2022/0475

Description: Extension to existing outbuilding (retrospective)

Site Address: 1 Redminster Barn, Towngate, Thurlstone, Barnsley, S36 9RH.

Plan - Scale 1:50

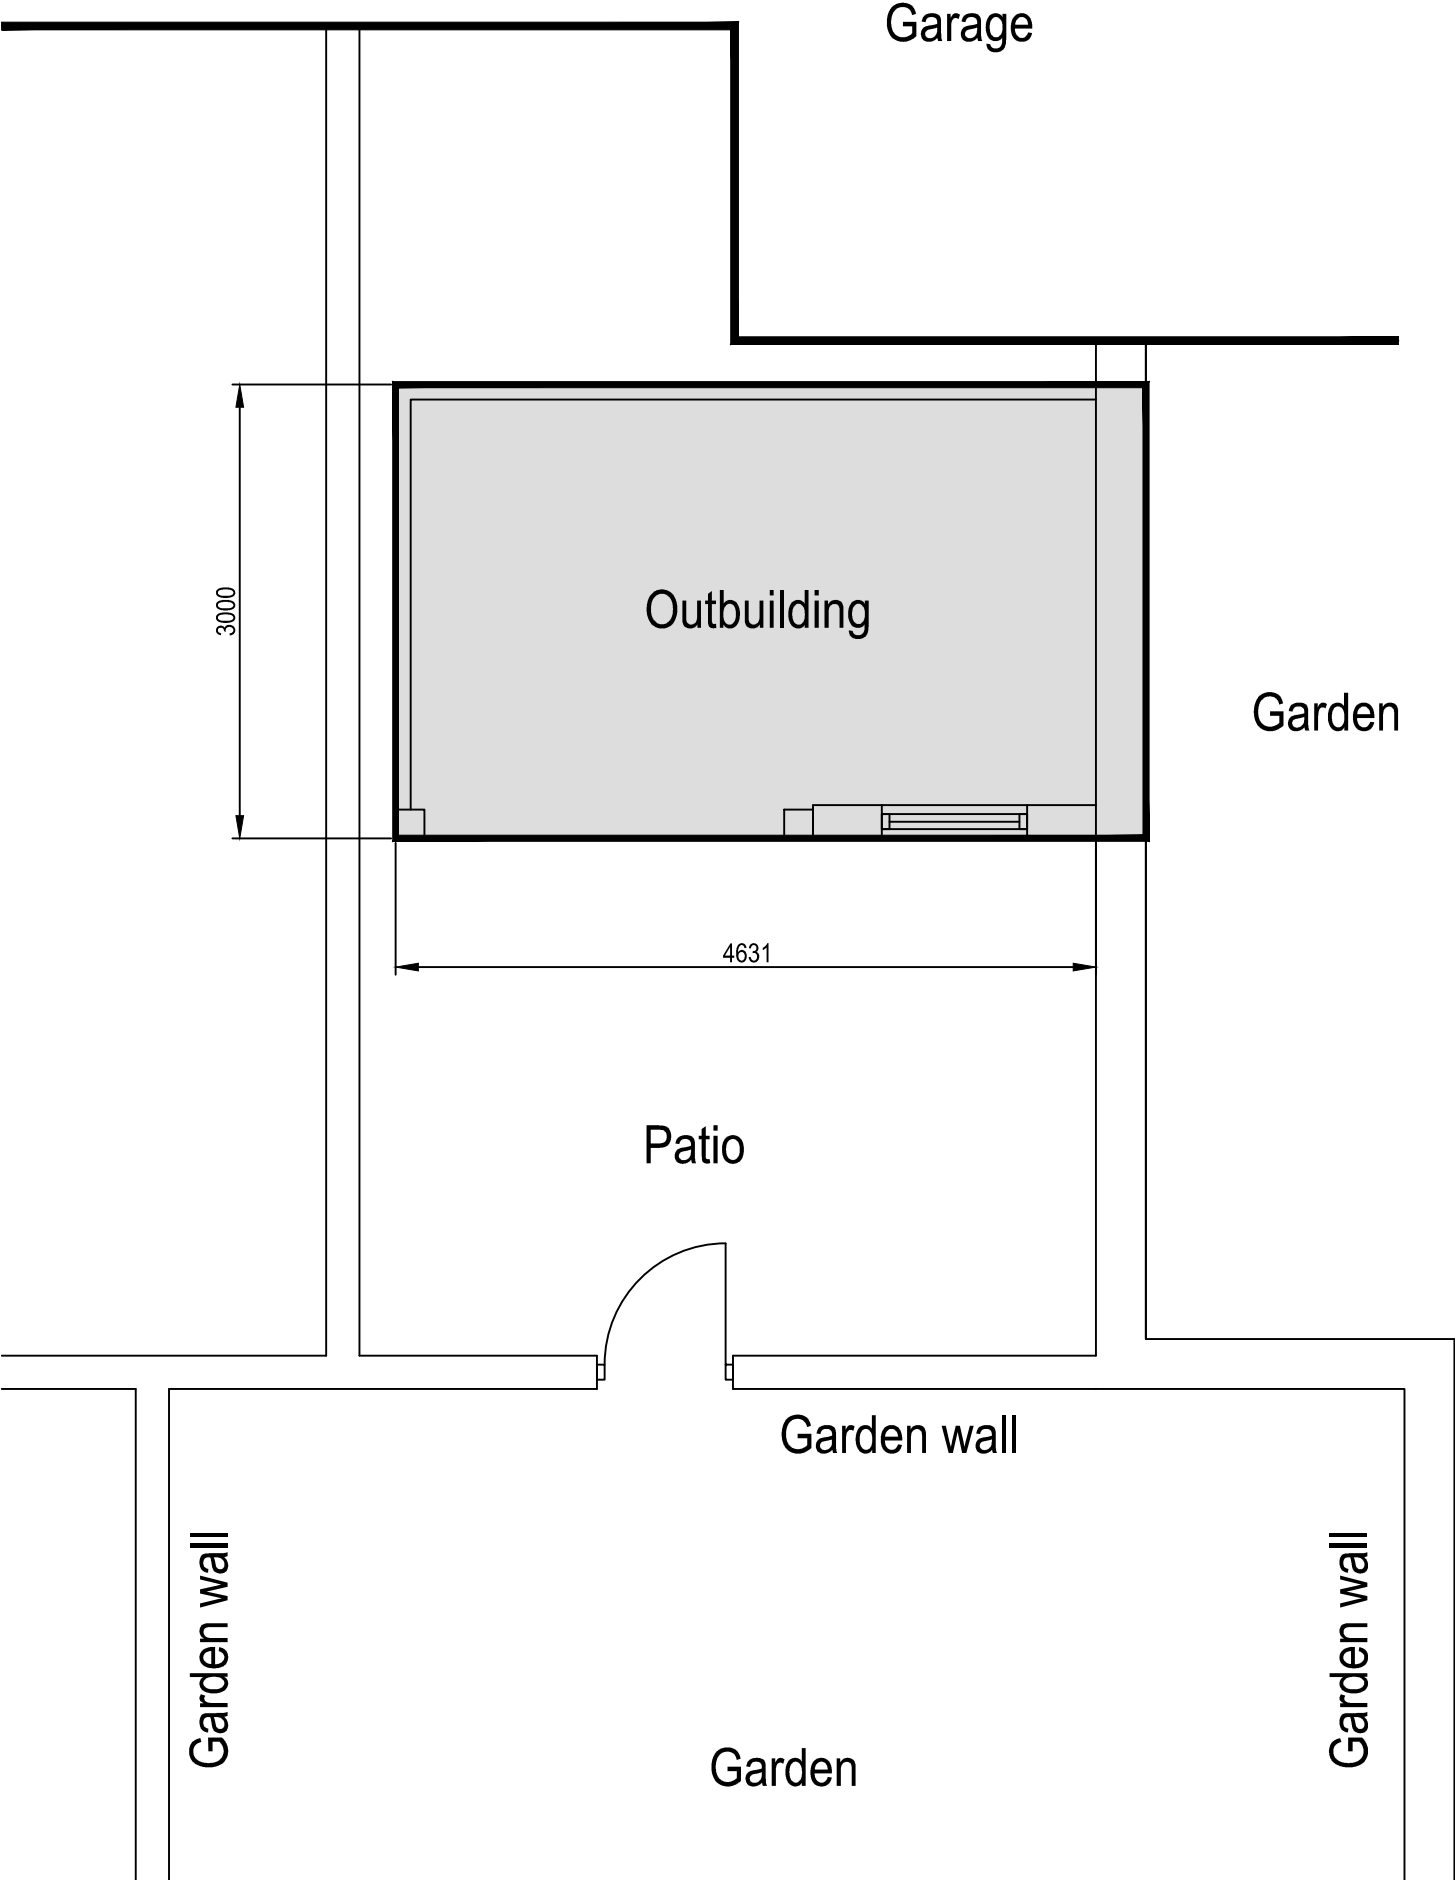
- True impact of the extended outbuilding has not been addressed within the submitted documents.
- Outbuilding extension has been built directly in front of our window (1.6m) and property (a Grade II listed building).
- Limits all maintenance, in addition to visibility and daylight.
- Actual dimension is only 1.6m from window to the rear of the constructed outbuilding.
- Blocks access to natural light.
- Window to our listed building is 300 years in existence and forms part of the listed status of our home.
- Completely blocked every benefit due to the outbuildings immediate impact.
- Construction of outbuilding at its tightest is 0.5m, giving no access to maintenance.

- Redminster house has sight of the extended building from no less than 12 windows.
- Redminster Barn is listed and the extension to the outbuilding has been constructed directly in front of the listed structure.
- Timber panelling and felt roof do not compliment the surroundings and existing structure of stone and slate before its extension.
- Plan submitted is not to scale and fails to show the window in existence.
- Permitted development does not exist in a conservation area or when related to a listed property.
- Enforcement principles have no time bar in instances related to a listed building.

Concern has been raised by a neighbouring property that the outbuilding has been built directly in front of a window to a listed building, would limit visibility and daylight, access to natural light and blocks benefits. In addition, they state that the extended building can be seen from no less than 12 windows.

The extension to the outbuilding is adjacent to the garage adjoining Redminster House. Whilst the neighbour is correct in the fact the extension has been built in front of a window, the window serves a garage and as such is it considered to be acceptable considering the fact the window would not be serving a habitable room. The extension would not block any views from the main dwelling and as such there would not be a significant loss of light to windows with habitable rooms.

In terms of outlook, whilst it is acknowledged that views would be visible from the dining room and kitchen windows, the outbuilding is single storey and is sited approximately 8.85m from the habitable rooms of the neighbouring property which is considered to be sufficient. Further,

the small extension to the outbuilding would not detrimentally alter the views the neighbouring property currently enjoys considering there is no increase in height and rather just a small extension, increasing the depth and the width of the outbuilding.

The extension to the outbuilding is modest, would not increase the height and is considered to remain subservient to the main dwelling. Further, the main material of the outbuilding is still stone and therefore the original character of the outbuilding is retained. It is considered therefore that is acceptable from a visual amenity point of view and would be in accordance with policy D1.
